Nil's Mediterranean Cuisine
16 N. Broad St.
Angier, NC 27501

The plans and specifications for the above referenced food service facility were reviewed and are disapproved at this time due to the following:

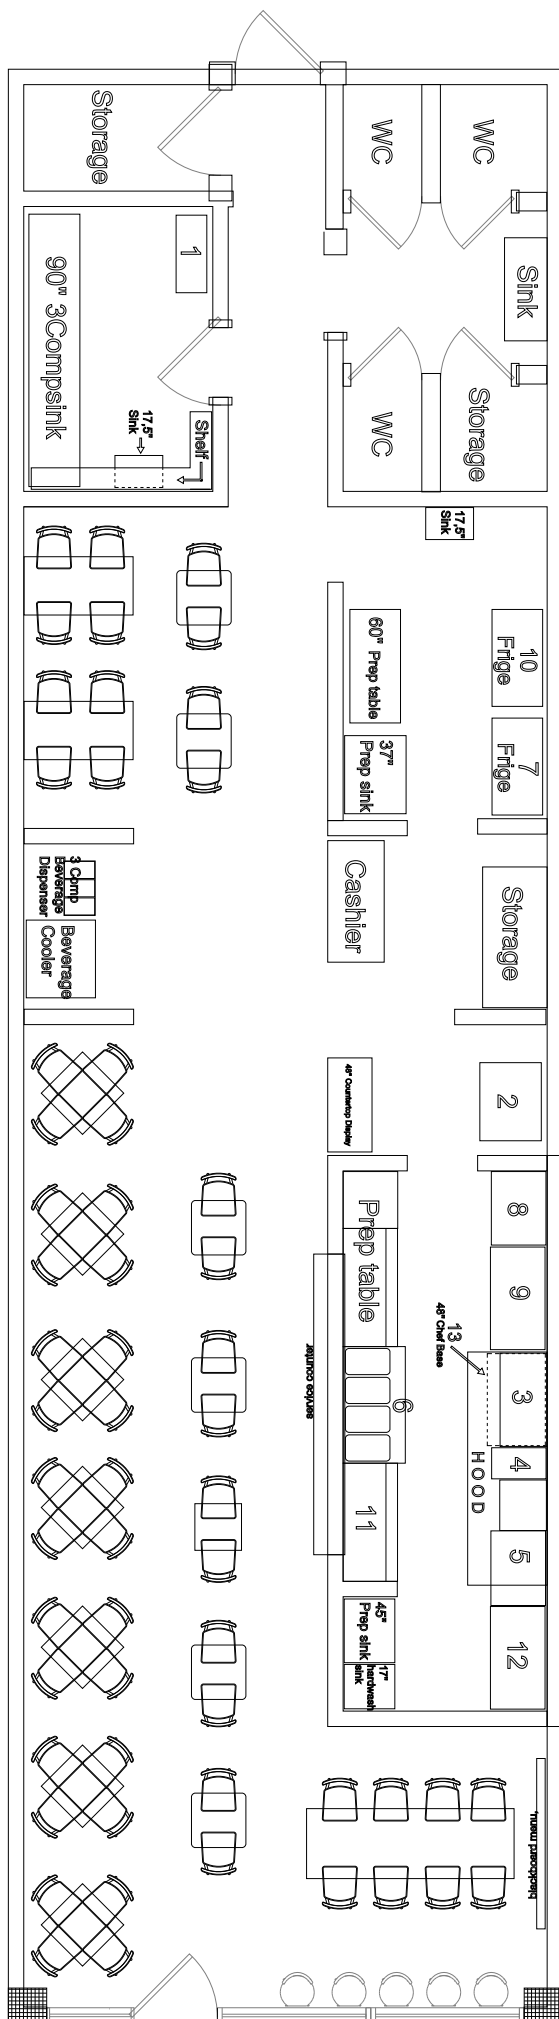
1. Provide a site plan showing all equipment, location of dry good storage dishwashing areas, can wash and dumpster area. Words on site plan are not legible.
